Our Ref: EN070009

Date: 22 April 2024

Application by H2 Teesside Limited for an Order Granting Development Consent for the H2Teesside

Advice following issue of decision to accept the application for examination

H2 Teesside
 Viewpoint 5: South Gare Breakwater
 Figure 16-7-2c Wireframe

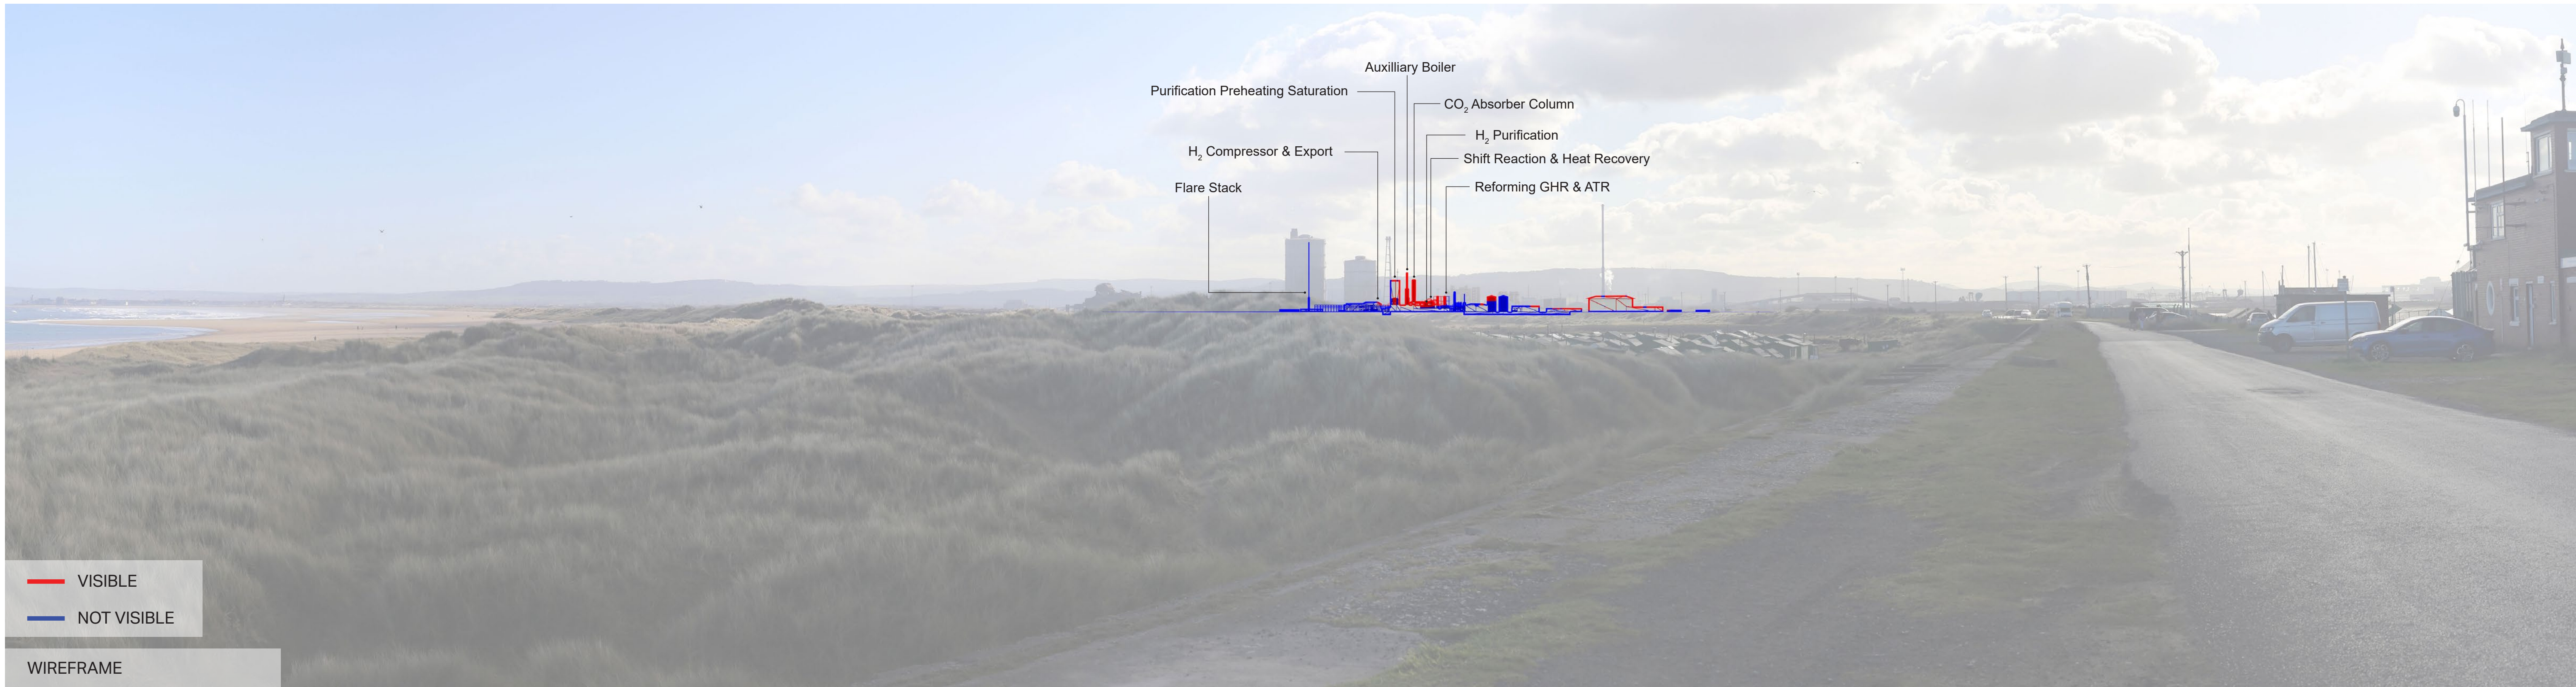
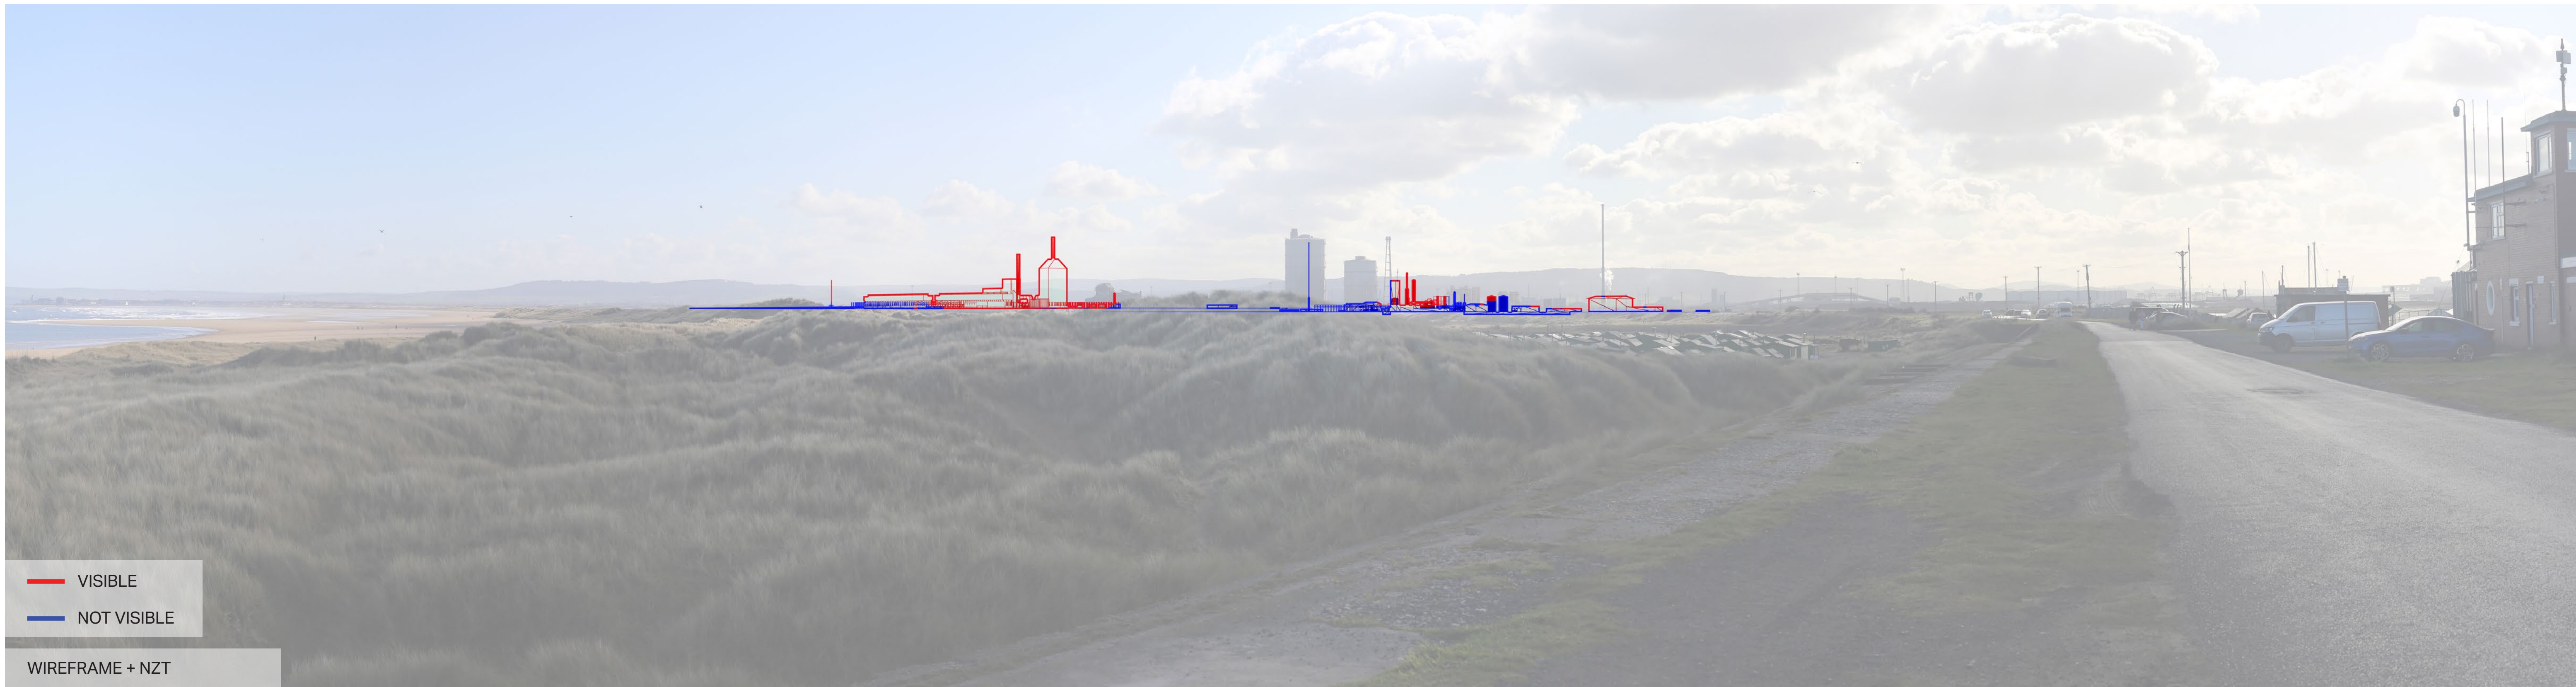
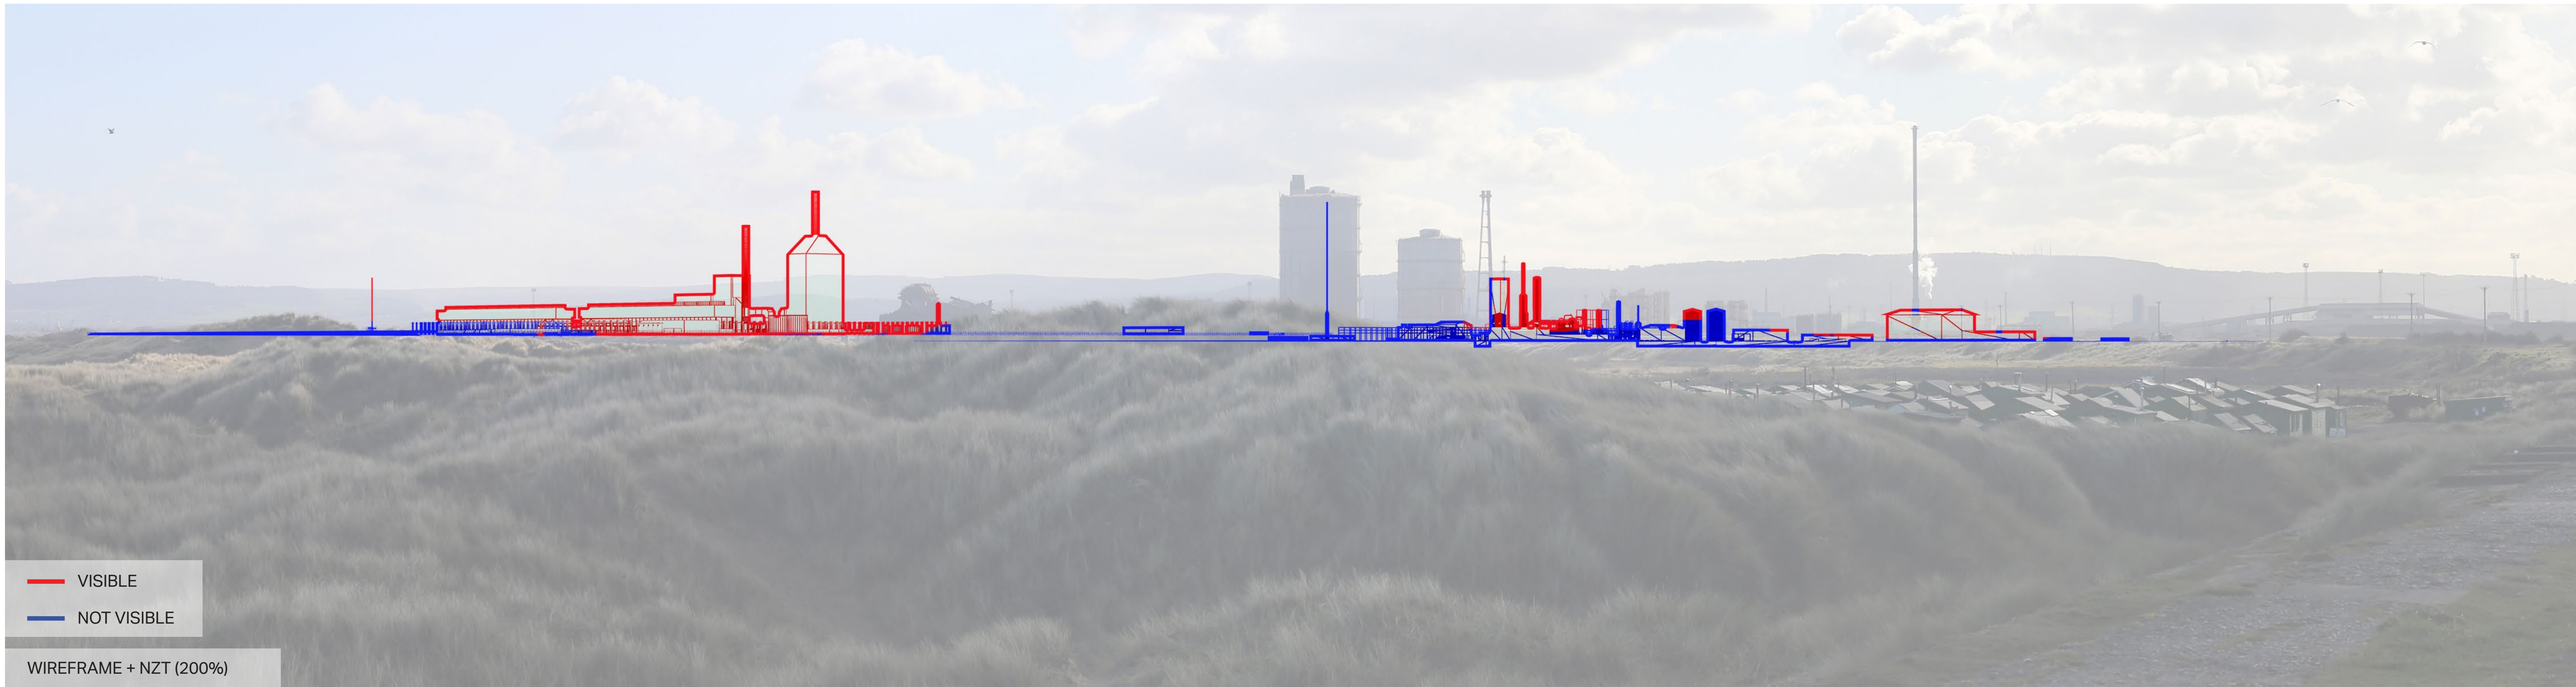
- Updated indicative pipeline plans to show:
 - Typical elevation of above ground pipelines in context with surrounding features.
- Photomontages:
 - Update to the photomontage document to include revised base photography showing the current views of the site, or explain why this is not possible or signpost where in the submitted documents you have explained why up to date baseline photography has not been used.
 - Please provide a photomontage document that labels the main features of the proposed development in, as a minimum, the 'wireframe' view
 - Please provide a version of the photomontages, using the same viewpoints as the current photomontages, at 200% enlargement detailing the Proposed Development with and without the consented Net Zero Teesside project.
